**ADC Planning Consultation
Response from the Historic Buildings Adviser**

Application Number	AB/112/14/L
Address	23 King Street Arundel BN18 9BJ
Description	Application for listed building consent to remodel existing house, including the upgrade of walls with insulated plasterboard, addition of 2 No new doors & 1 No new window on ground floor, removal of external wall render on first floor and change of design of roof over rear utility and WC.
Case Officer	Anita Gardner
Site Visit	1 October 2014

Elevations

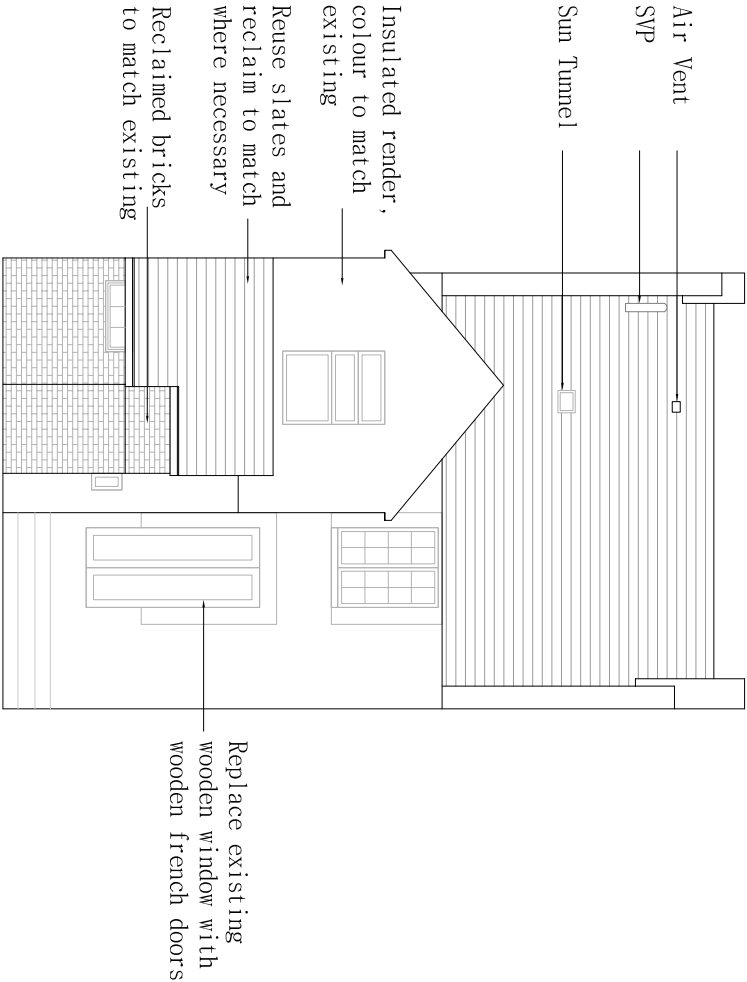
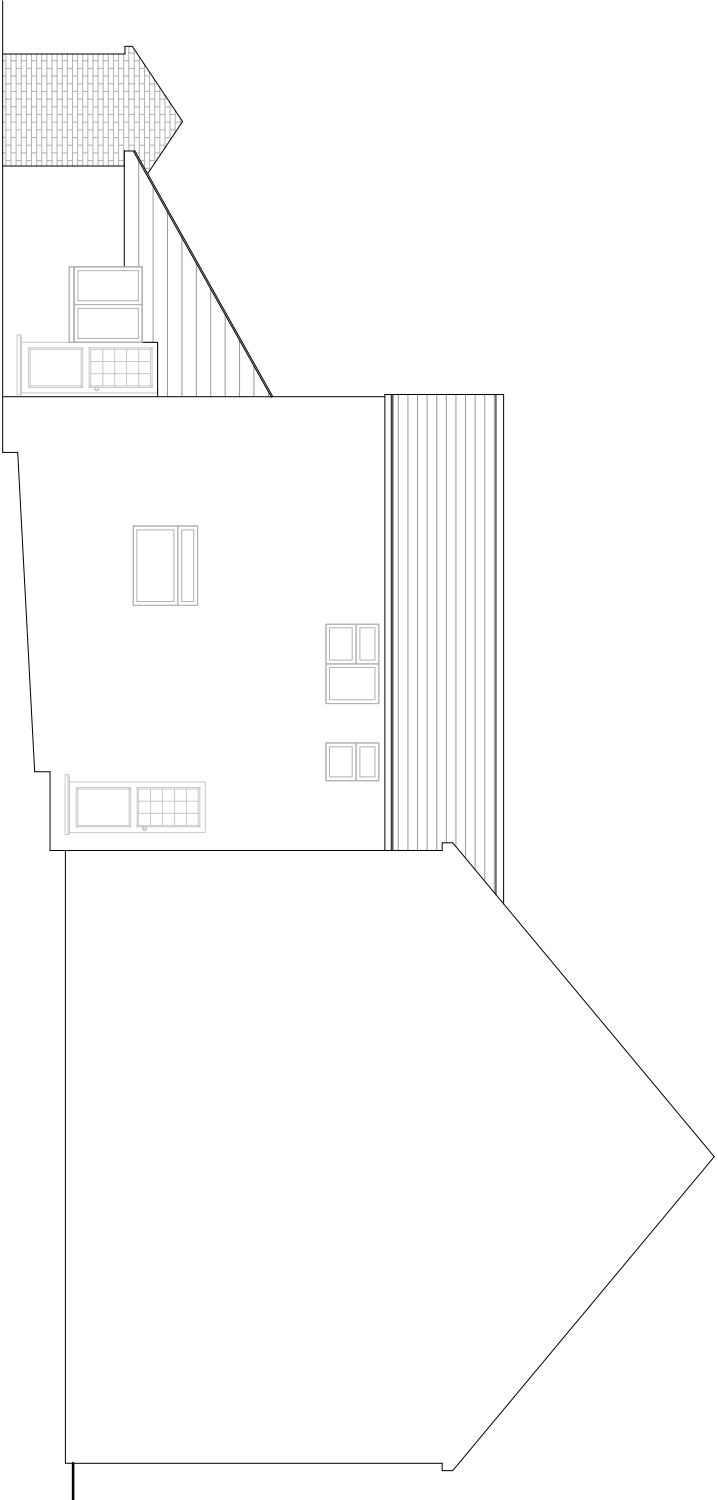
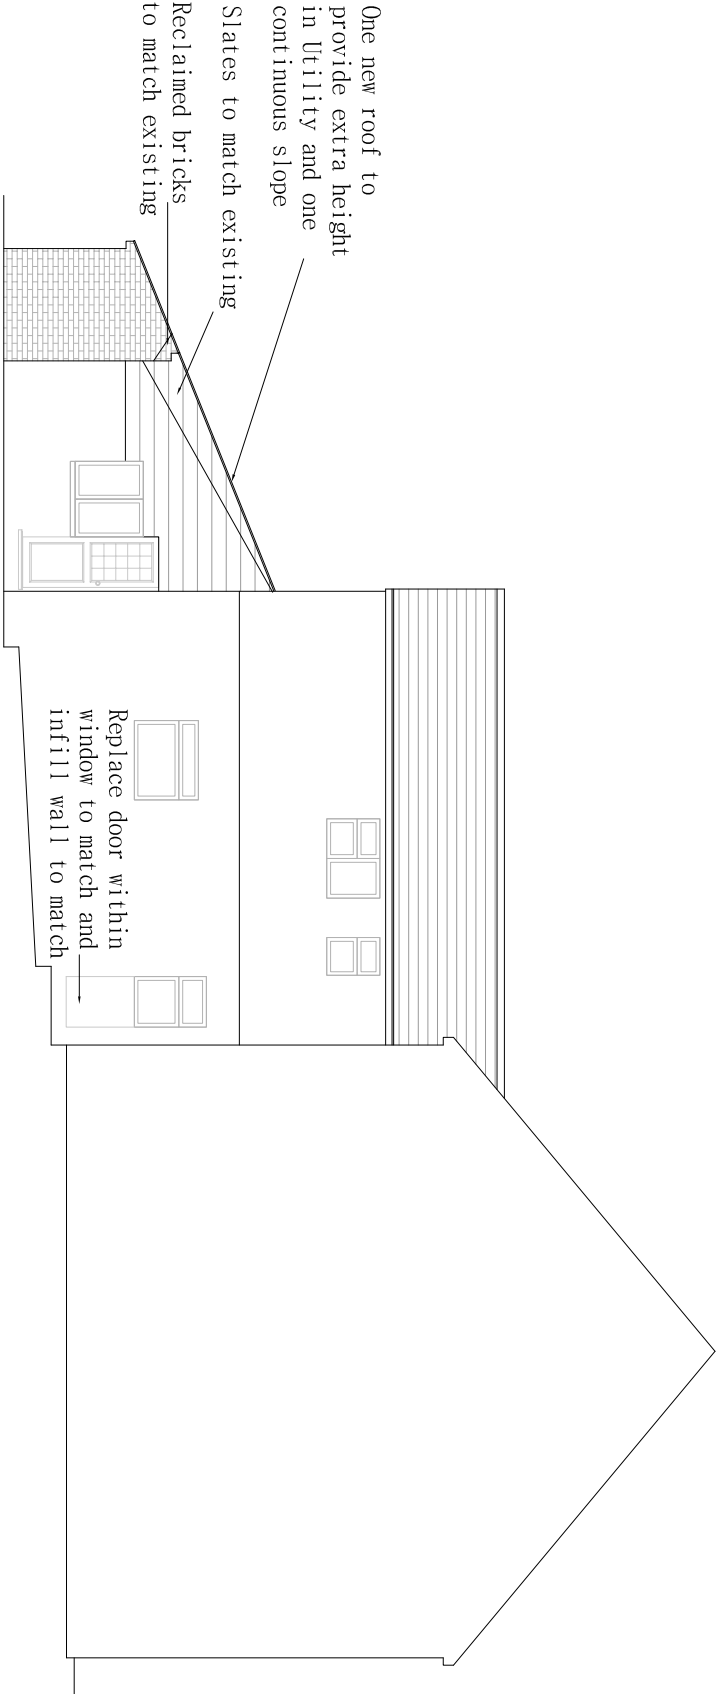
- The use of insulated render on the exterior is unlikely to be acceptable as breathability needs to be maintained. How this insulation is going to impact the building and its fabric is also not understood.

Proposed Roof Plan

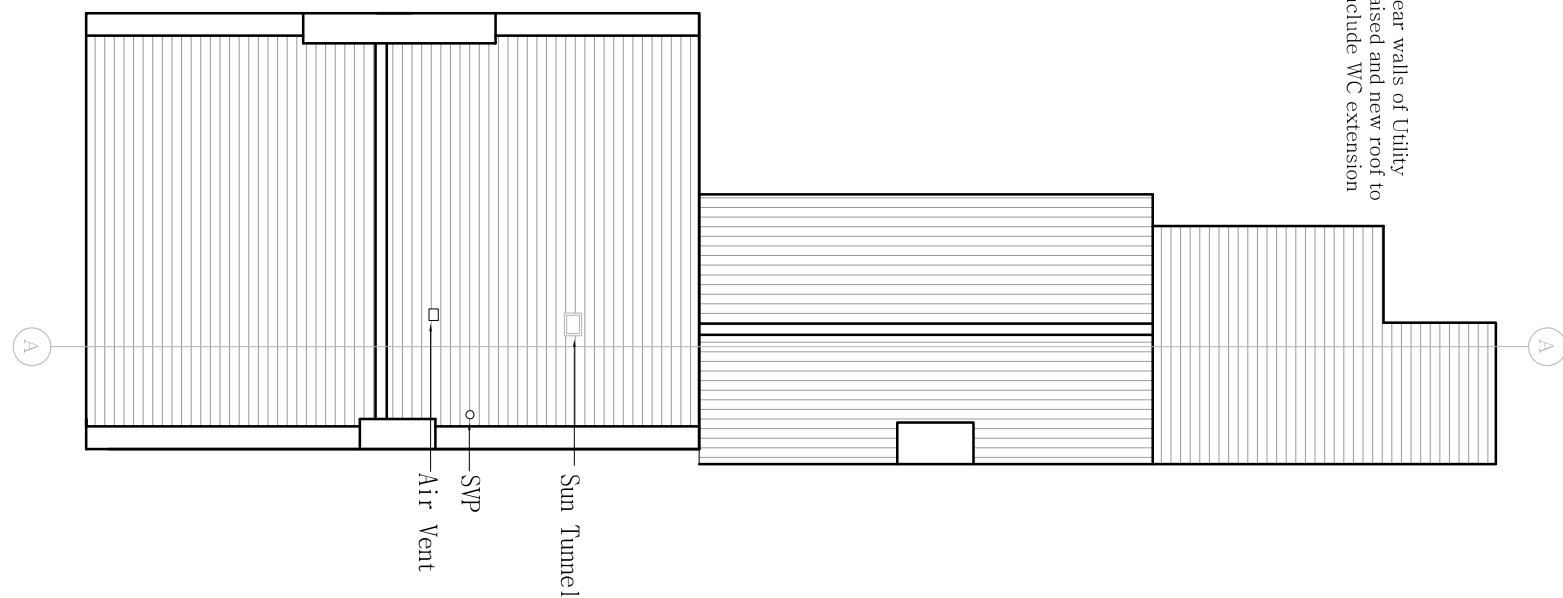
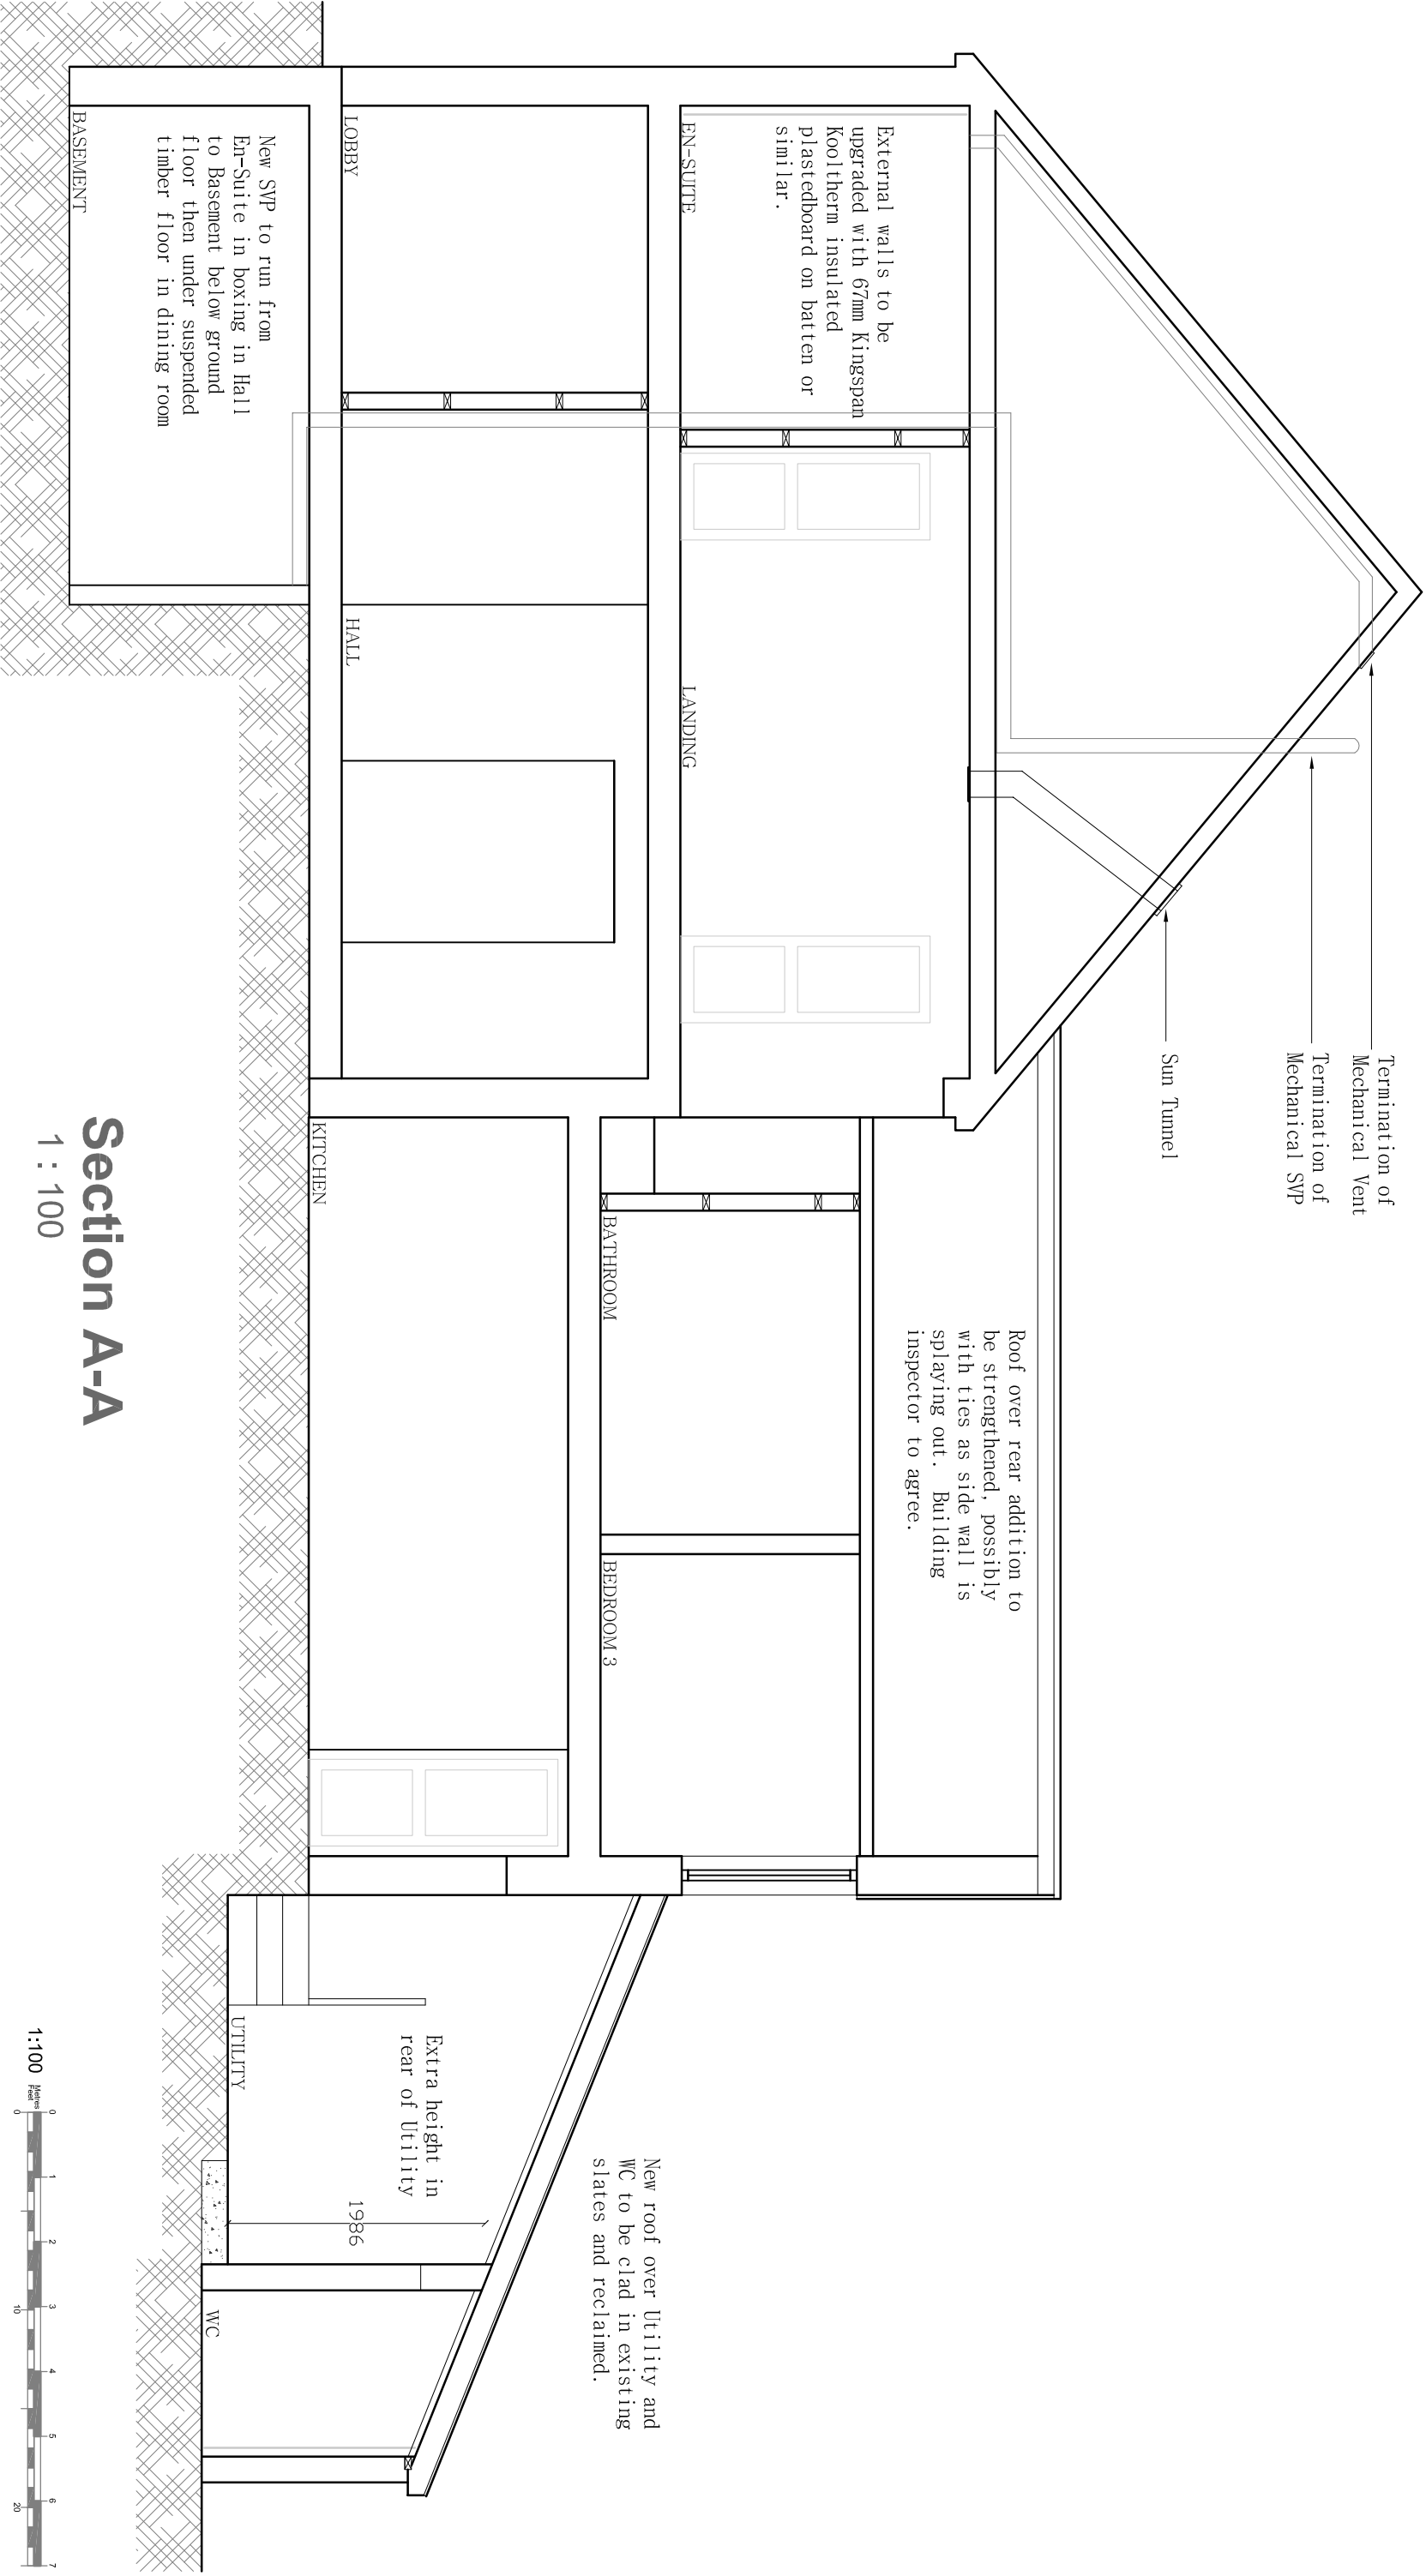
- The raising of the roof at the rear results in a more shallow roof pitch which is not particularly sympathetic as a building form. These two elements should be retained.

**Details of New
Single-glazed
Timber Window
to Replace
Existing Door**

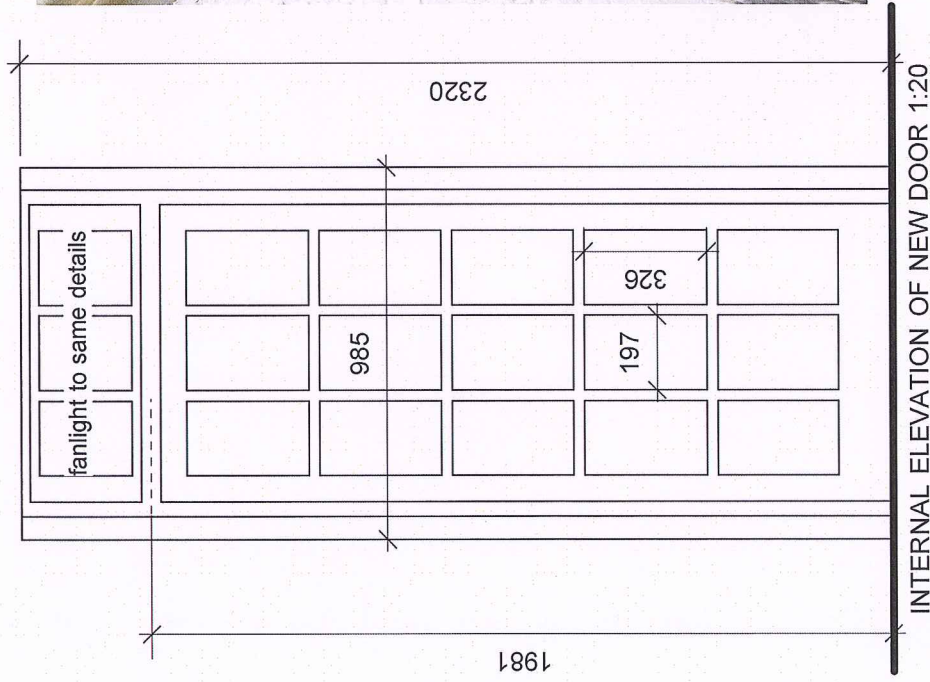
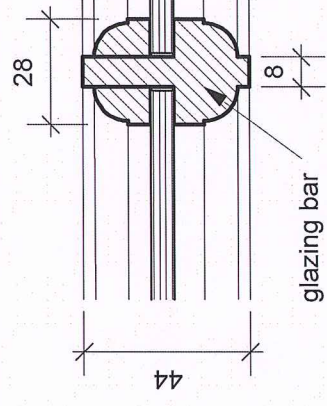
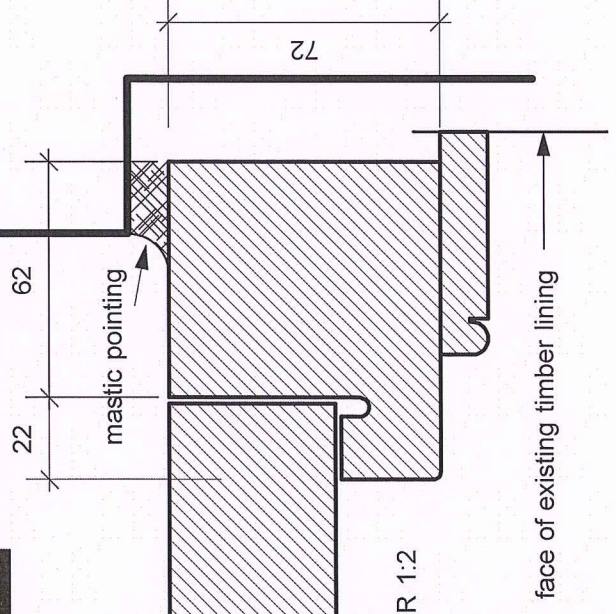
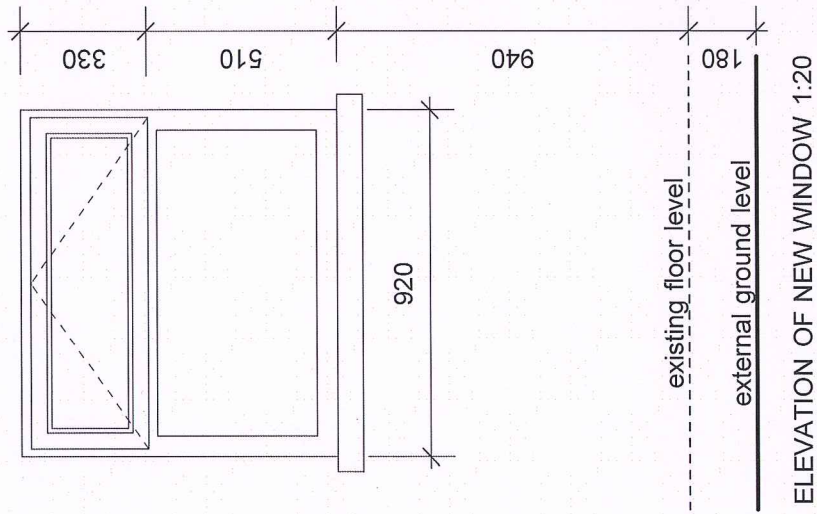
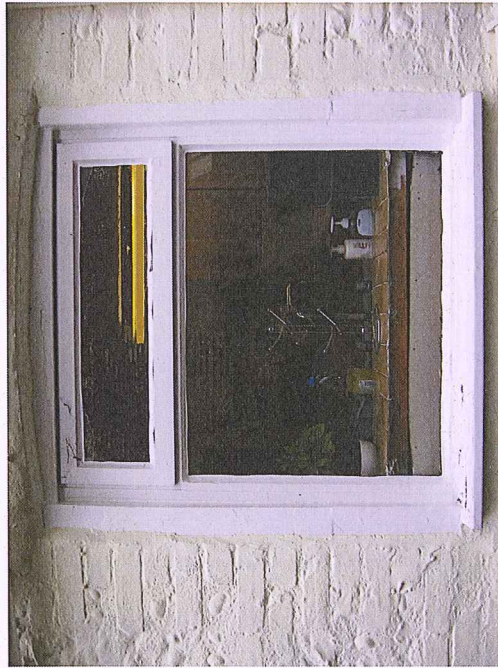
- The design of the window to replace the door to the rear is not acceptable. Top vents should be avoided in buildings of this period.
- The replacement of the window with French doors is likely to be acceptable subject to design.
